**KIRKLEES METROPOLITAN COUNCIL
INVESTMENT & REGENERATION SERVICE**

**DELEGATED DECISION TO DETERMINE PLANNING APPLICATION FOR
ADVERTISEMENT CONSENT**

Reference No:	2025/64/93135/W
Site Address:	adj, 30, John William Street, Huddersfield, HD1 1BG
Description:	Advertisement Consent for one internally illuminated sign (within a Conservation Area)
Recommending Officer:	Joanna Rednall

DECISION – REFUSE ADVERTISEMENT CONSENT

| SITE PLAN                                                 | 23/10/2025     |          |

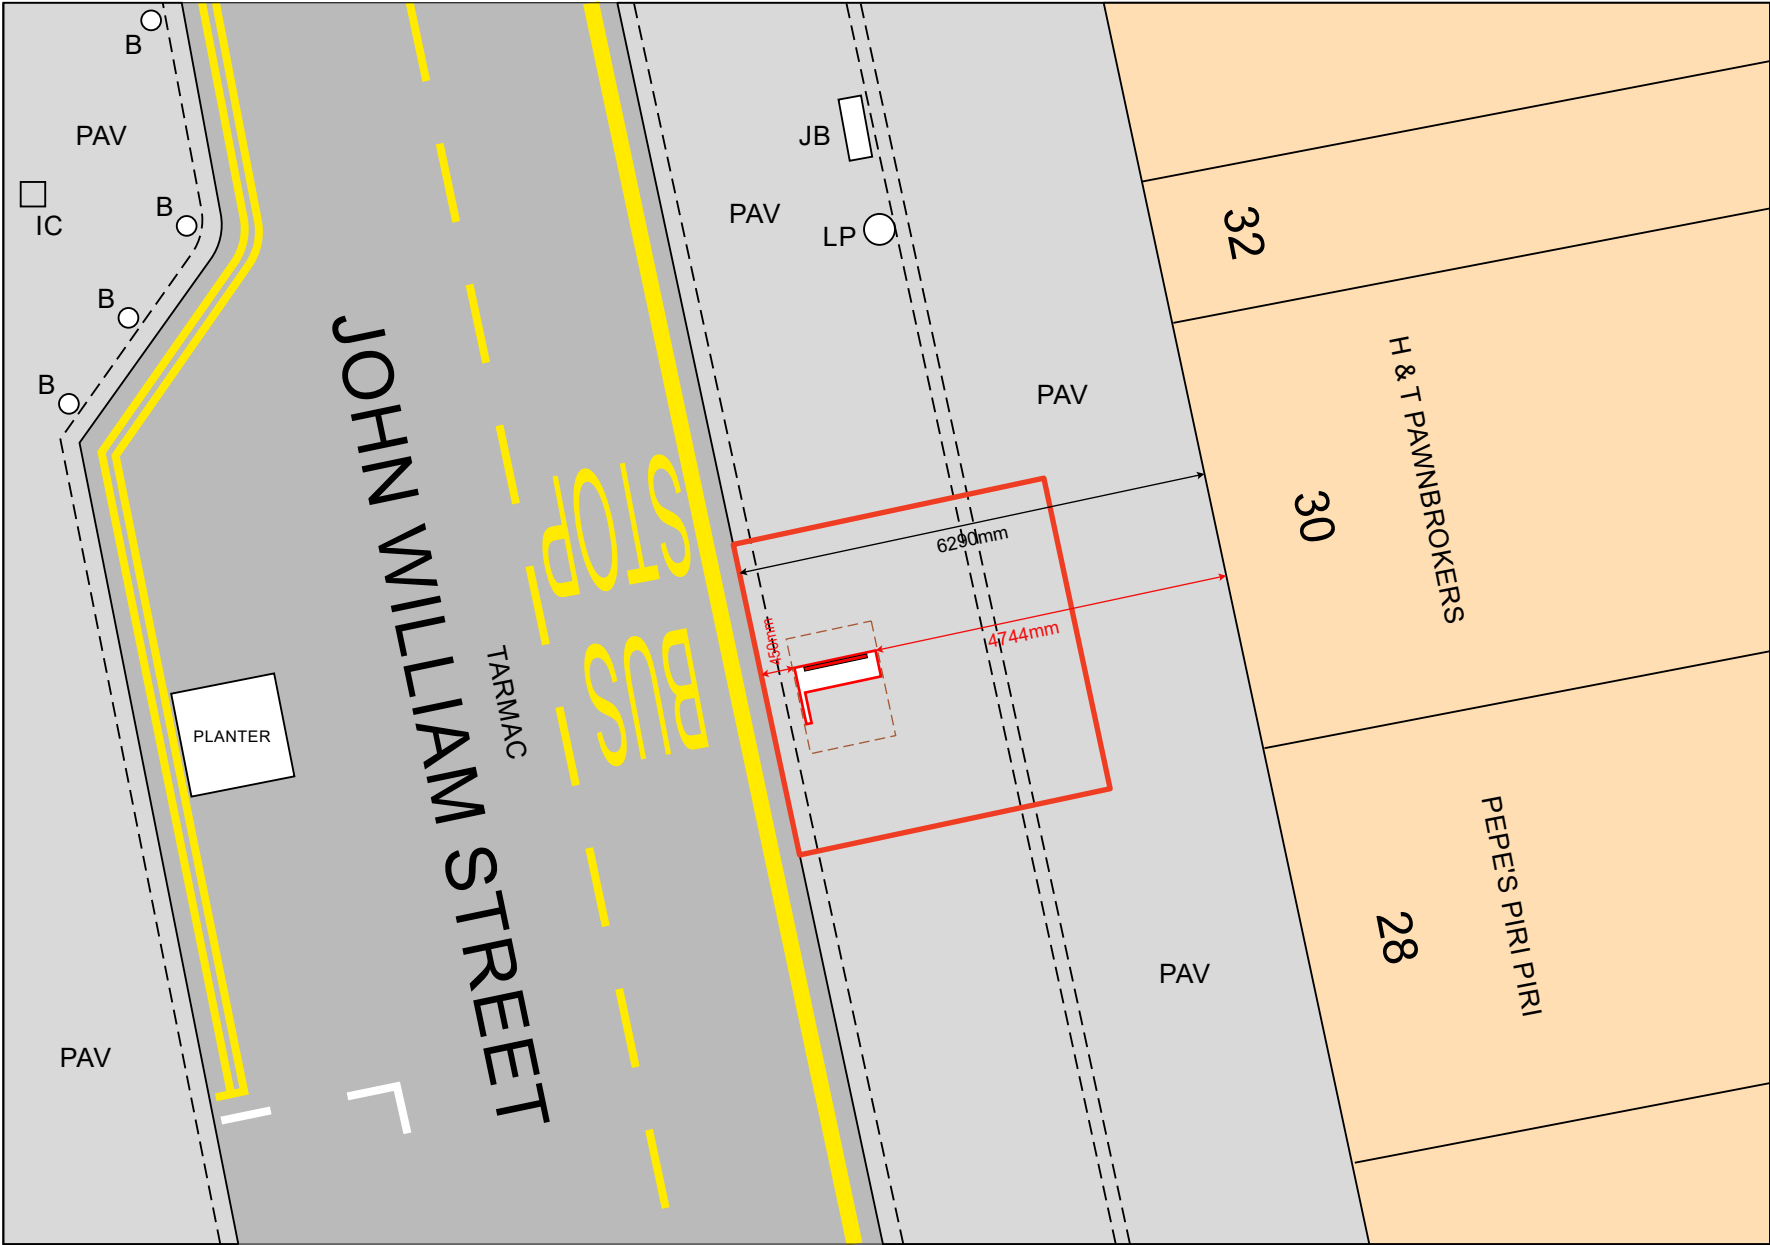
The proposal seeks consent for a 1.6 m × 0.9 m advertisement to be displayed on a communications kiosk outside 30, John William Street. The signage would face directly onto John William Street, placing it in a highly visible and prominent location.

an unsympathetic and intrusive element that is out of keeping with the historic character of the Huddersfield Town Centre Conservation Area. In addition, the advertisement would add to the existing visual clutter of the communications kiosk, further exacerbating harm to the Conservation Area by detracting from its historic setting.

1. The proposed advertisement, by virtue of its scale, illumination and prominent location, would form a visually jarring, intrusive and incongruous feature within the street scene, to the detriment of visual amenity and would fail to preserve the setting of Huddersfield Town Centre Conservation Area. The proposal would result in less than substantial harm to its significance of which sufficient public benefits have not been demonstrated to outweigh the proposed harm. To permit such development would be contrary to Policies LP24 (a), LP25 1 (a) and (b) and LP35 of the Kirklees Local Plan, Section 66(1) of the Planning (Listed Buildings and Conservation Areas) Act 1990, and Policies within Chapters 12 and 16 of the National Planning Policy Framework.
